**RE: Claremont Commercial Filing No. 2 Preliminary Plan (SP-17-004) – Review Response #3**

This letter responds to your March 7, 2018 review letter relating to the above referenced project. Responses to review comments are shown in **RED** below.

PRELIMINARY GRADING AND EROSION CONTROL PLAN

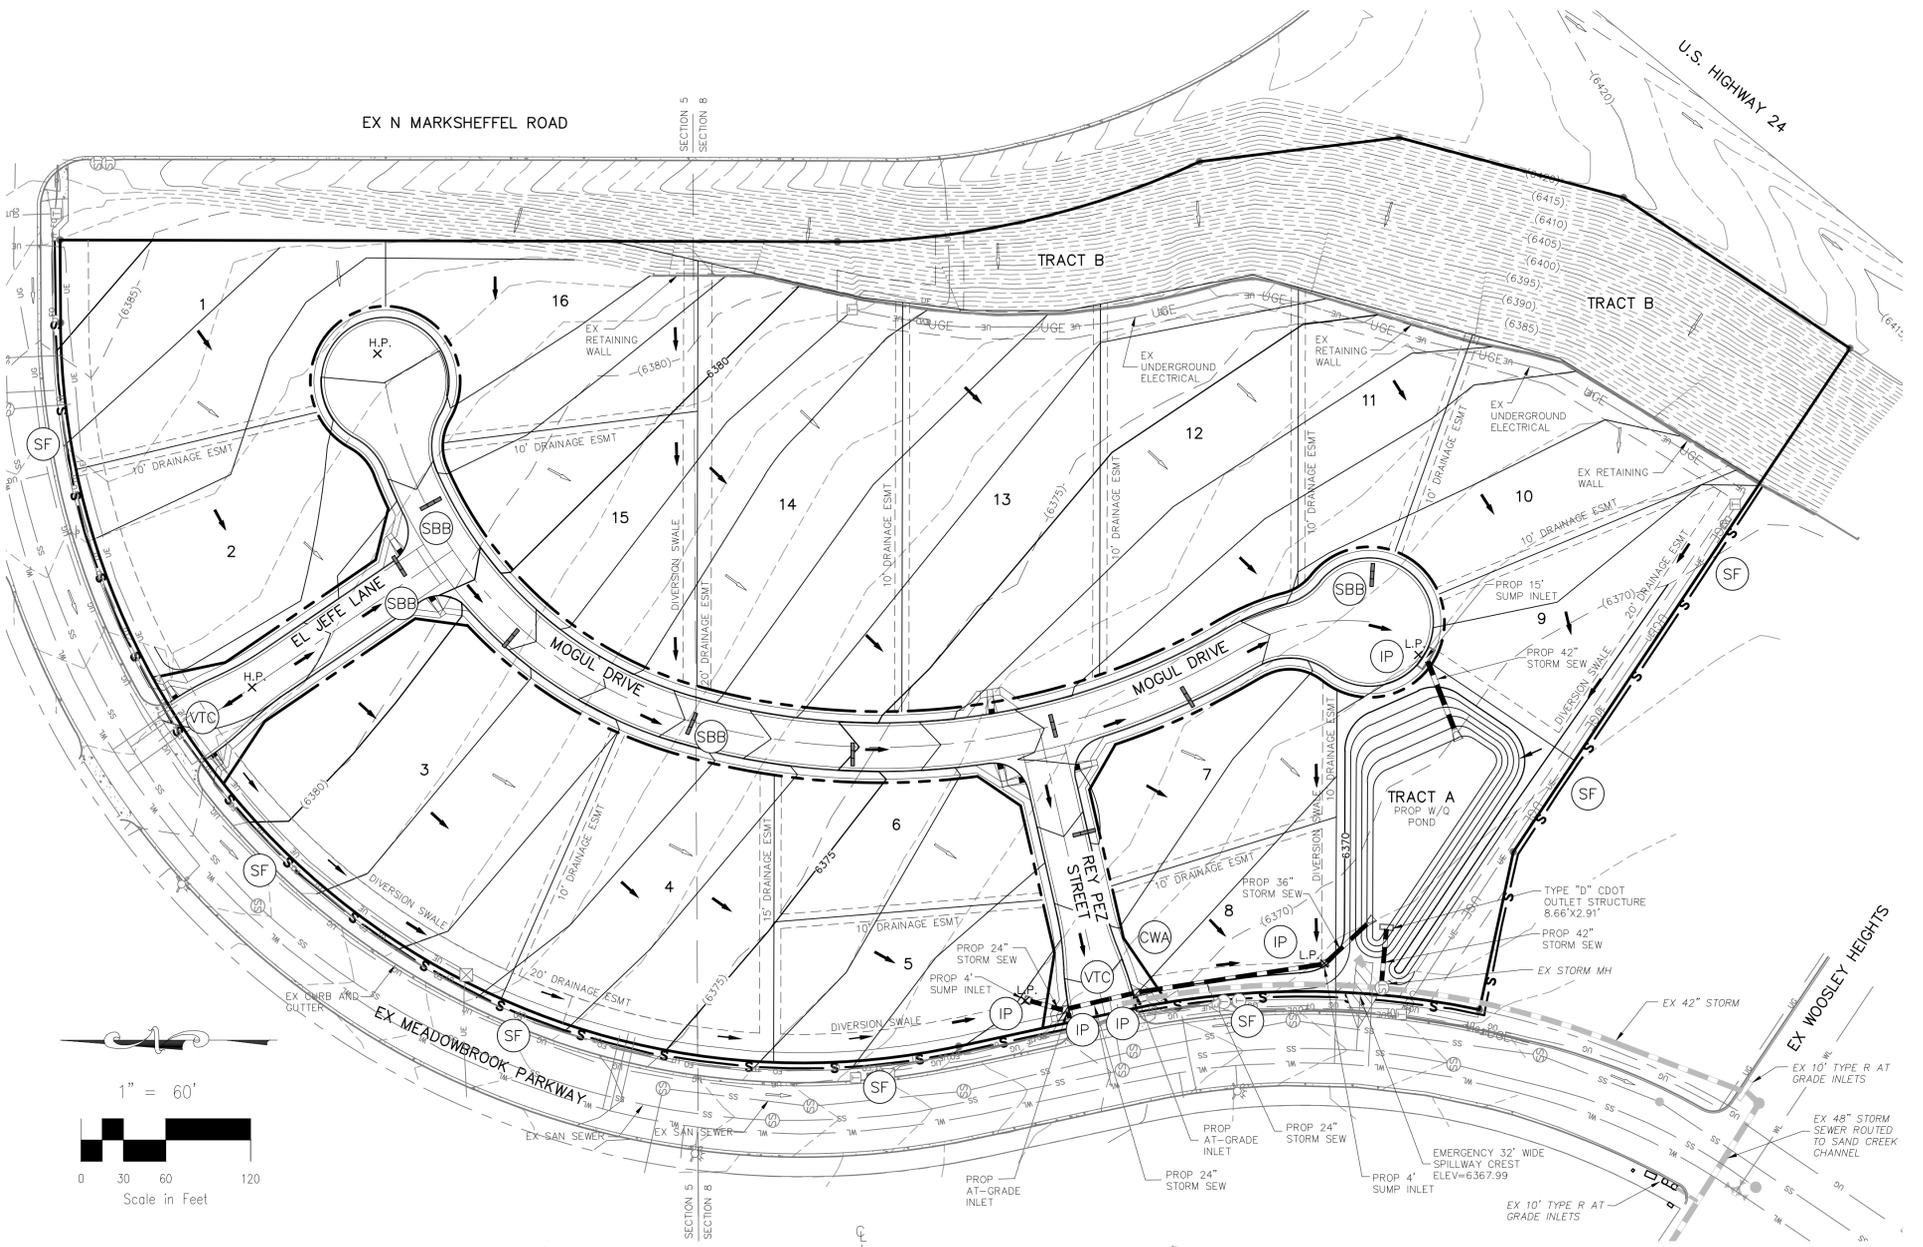
Comments resolved for the Preliminary Grading and Erosion Control Plan (GEC). Be advised: With the Final Plat the Grading and Erosion Control Plan shall be a standalone set with cover sheet and include all items listed in the GEC checklist in Appendix E of the ECM. The standalone GEC associated with the final plat shall include full construction details of the temporary and permanent BMPs. **Noted.**
